**KIRKLEES METROPOLITAN COUNCIL
INVESTMENT & REGENERATION SERVICE**

Reference No: 2020/62/91168/E

Site Address: 1, Patterdale Road, Dewsbury, WF12 7NP

Description: Erection of single storey side extension

Drawing Title
PROPOSED EXTN

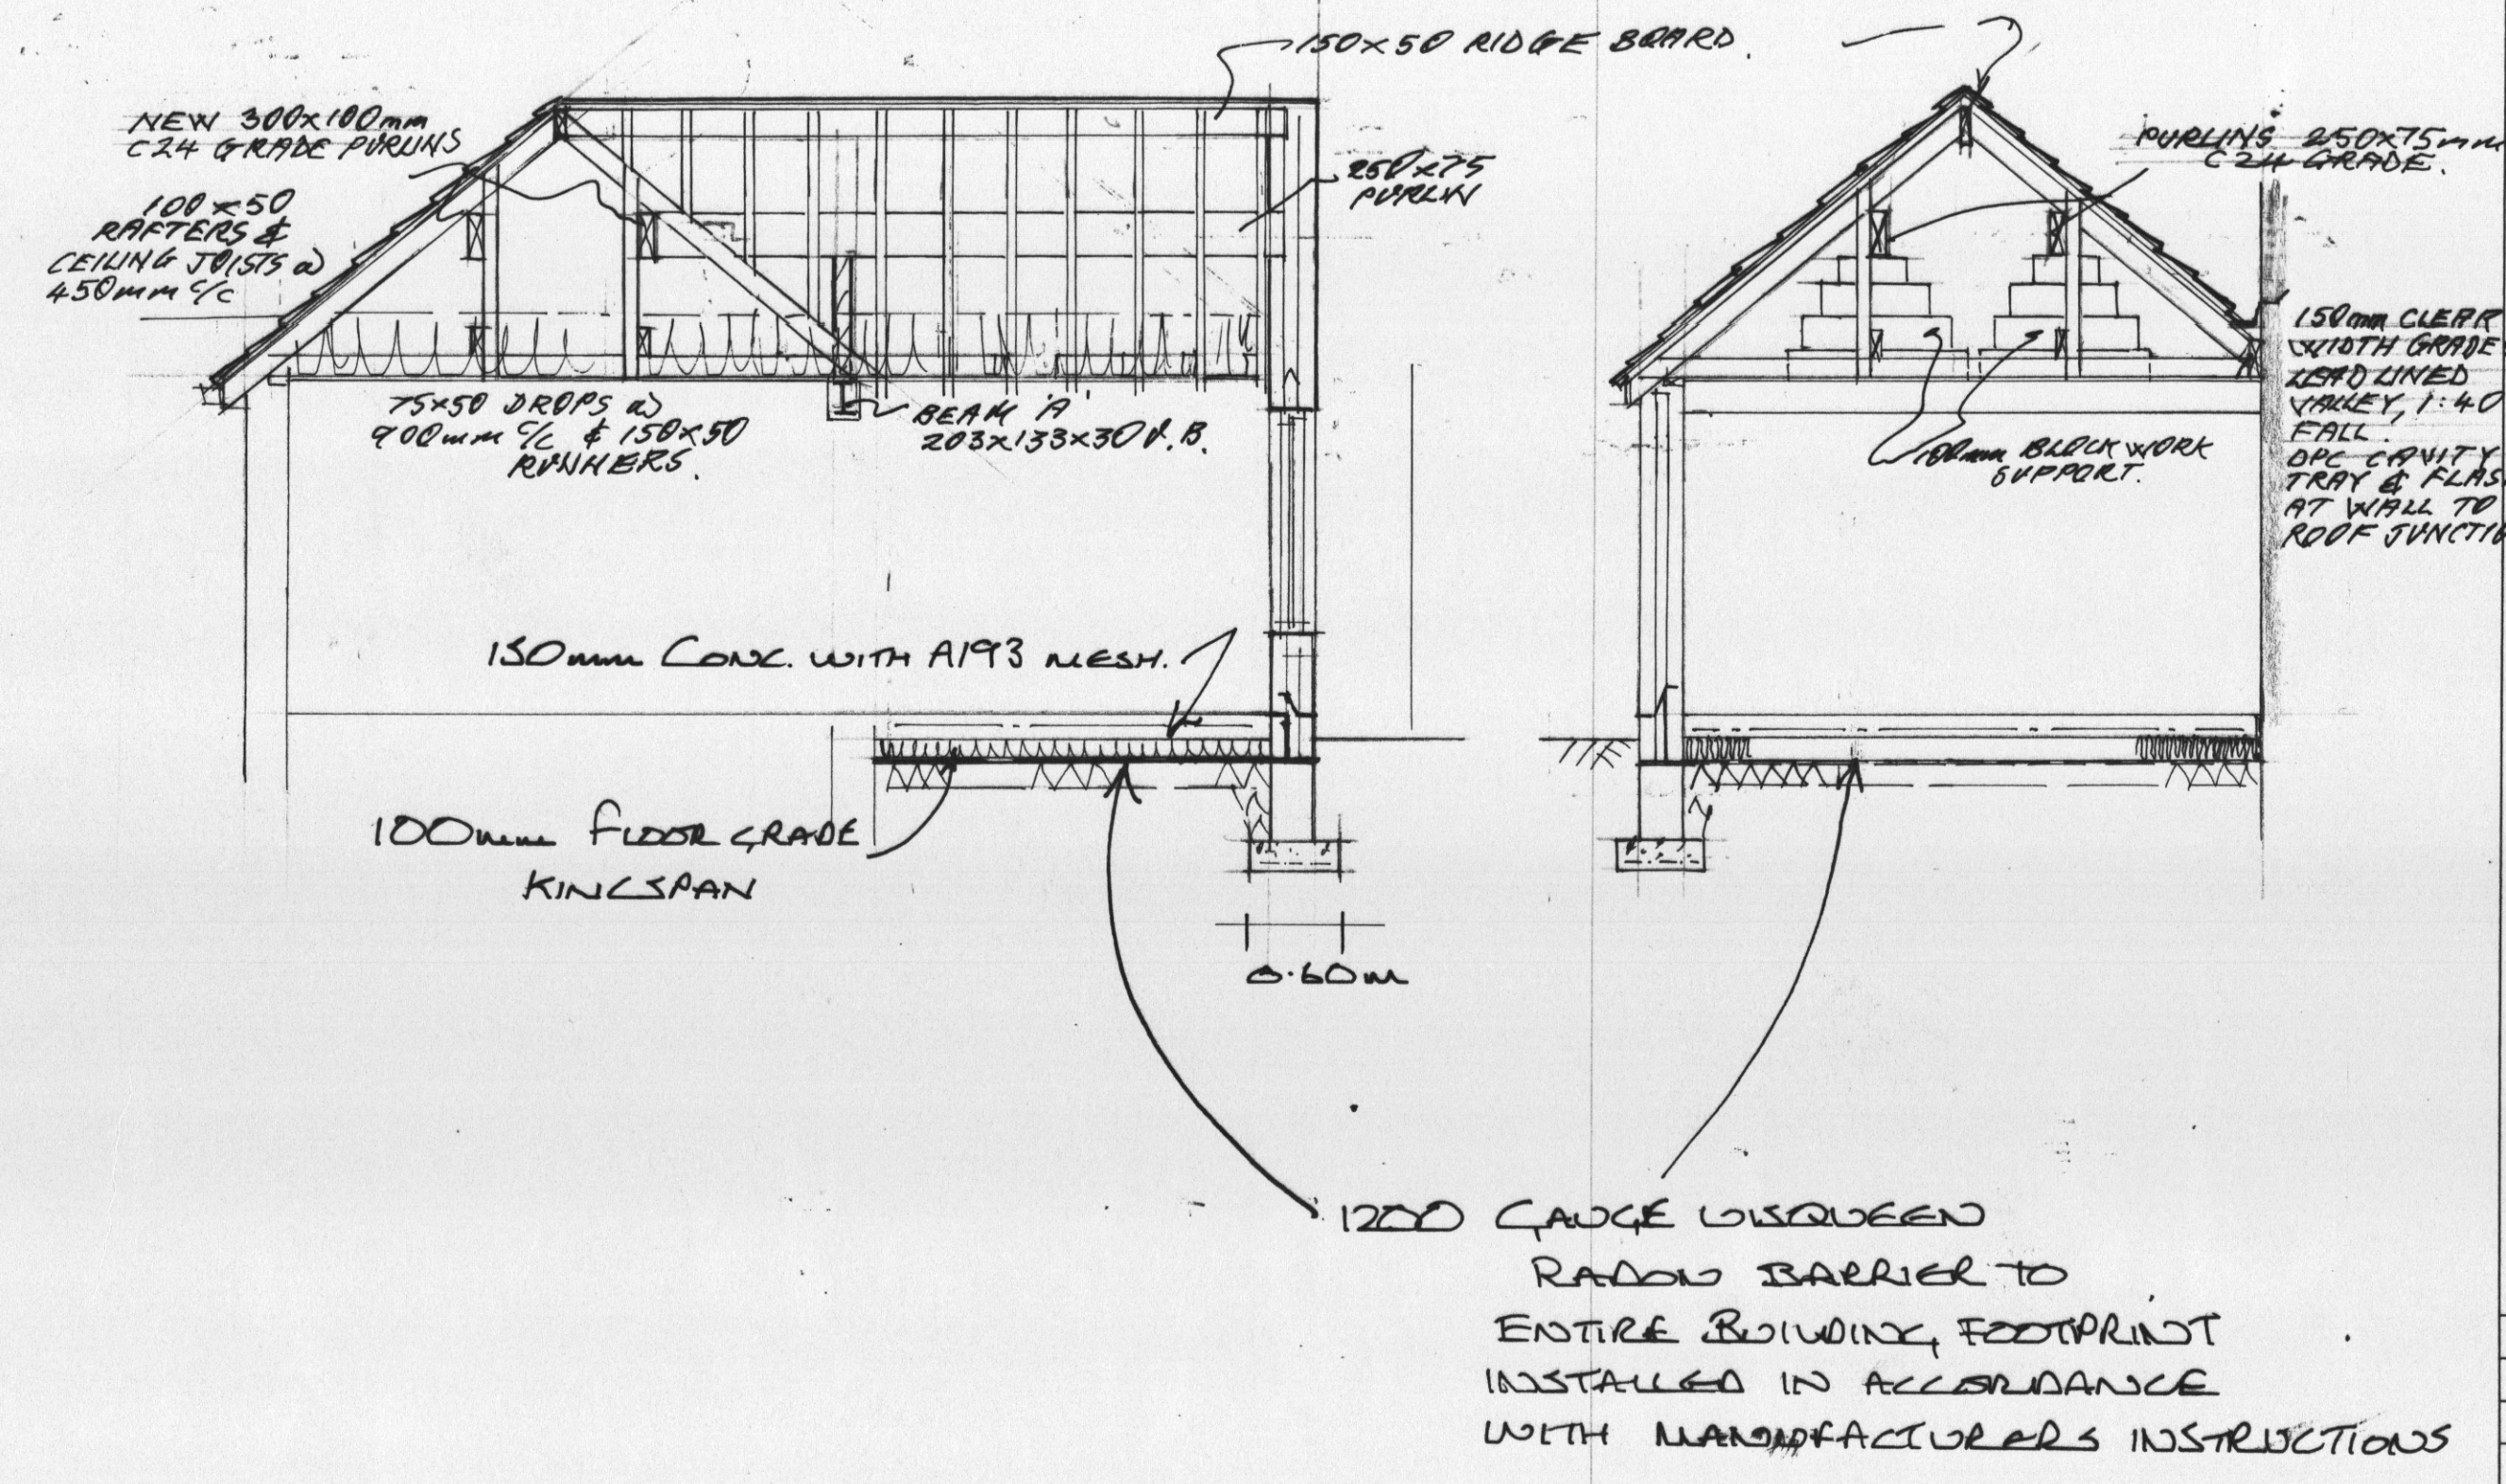
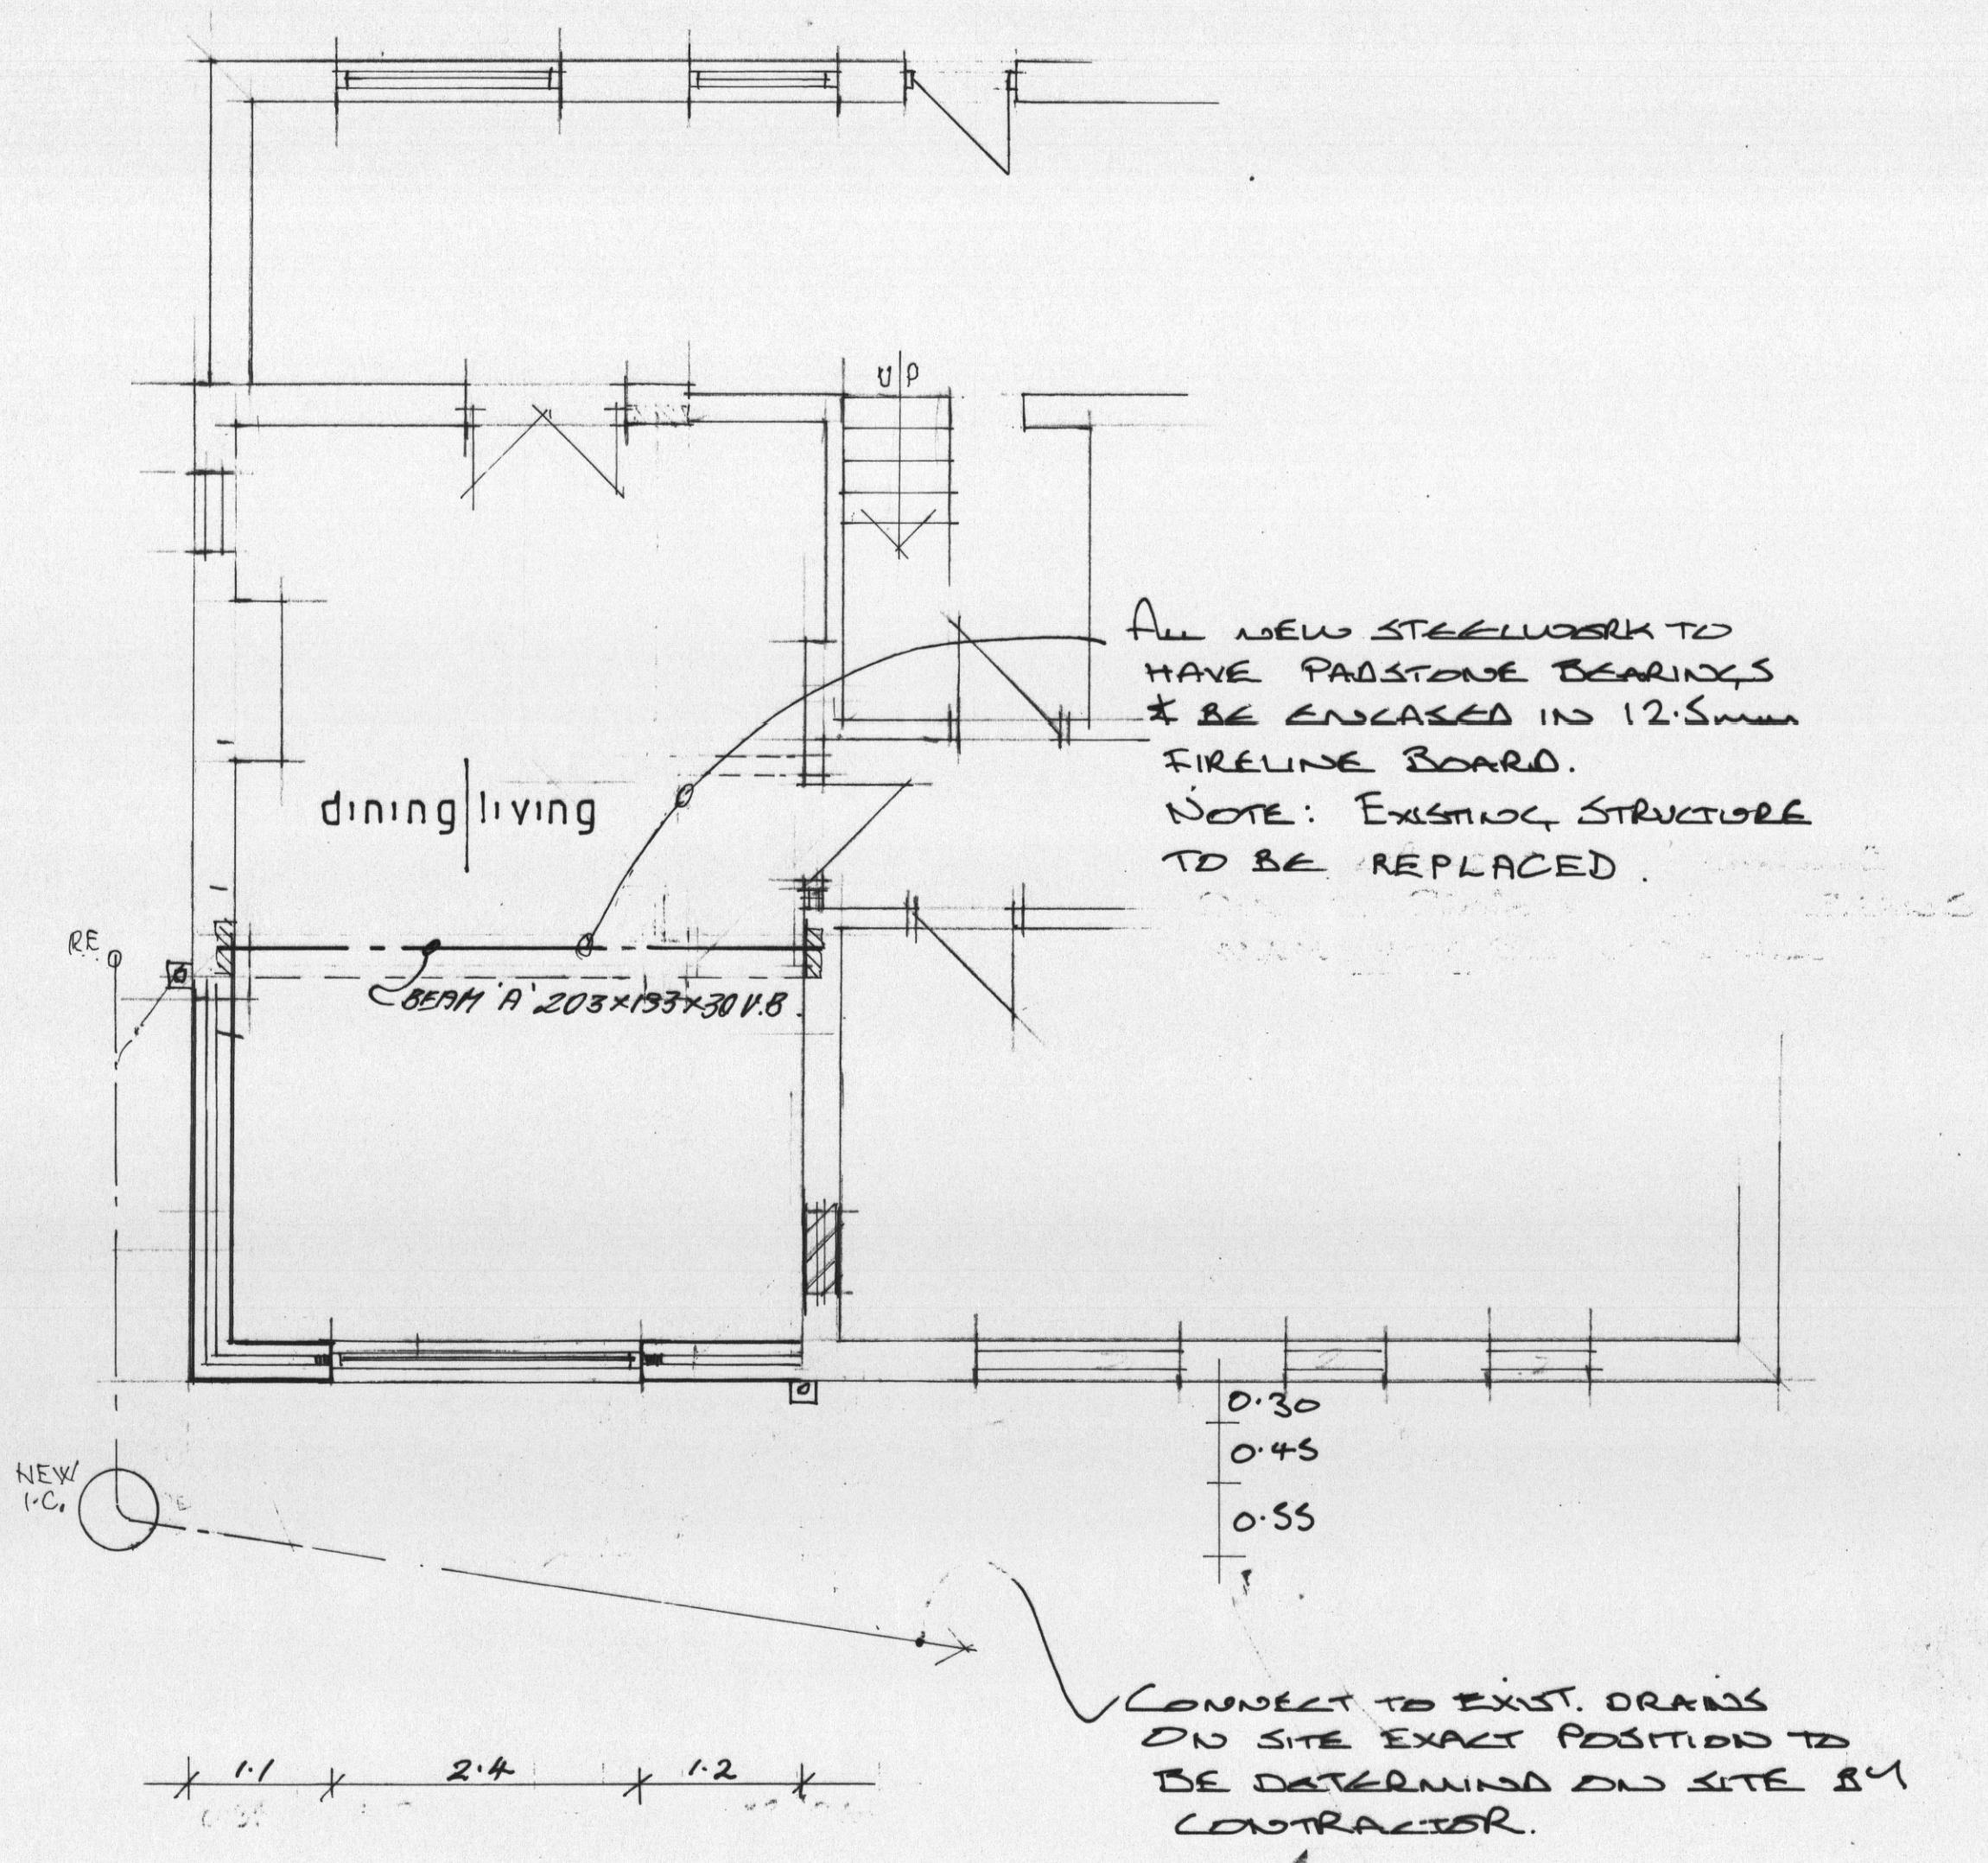
Amended plans were sought from the agent during consideration of the application to ensure that the submitted plans correspond with what has been built on site.

The amendments were limited to the correction of window openings. Whilst an opening has been introduced to the side elevation of the extension, given that the extension has been constructed and the opening is in place, it was considered that it would not be necessary for the amended plans to be advertised, in this instance.

overshadowing impact. There is a window in the side elevation of the extension, which serves a secondary opening to the living/dining room. Given the distance retained between the properties, as well as the fact that the application site is located at a slightly lower land level, it is considered that there would be no potential for harmful overlooking. This would be further limited by the existing boundary treatment, which comprises hedging.

Amended plans were sought, and received, during consideration of the application, to ensure that the submitted plans corresponded with what had been built on site.
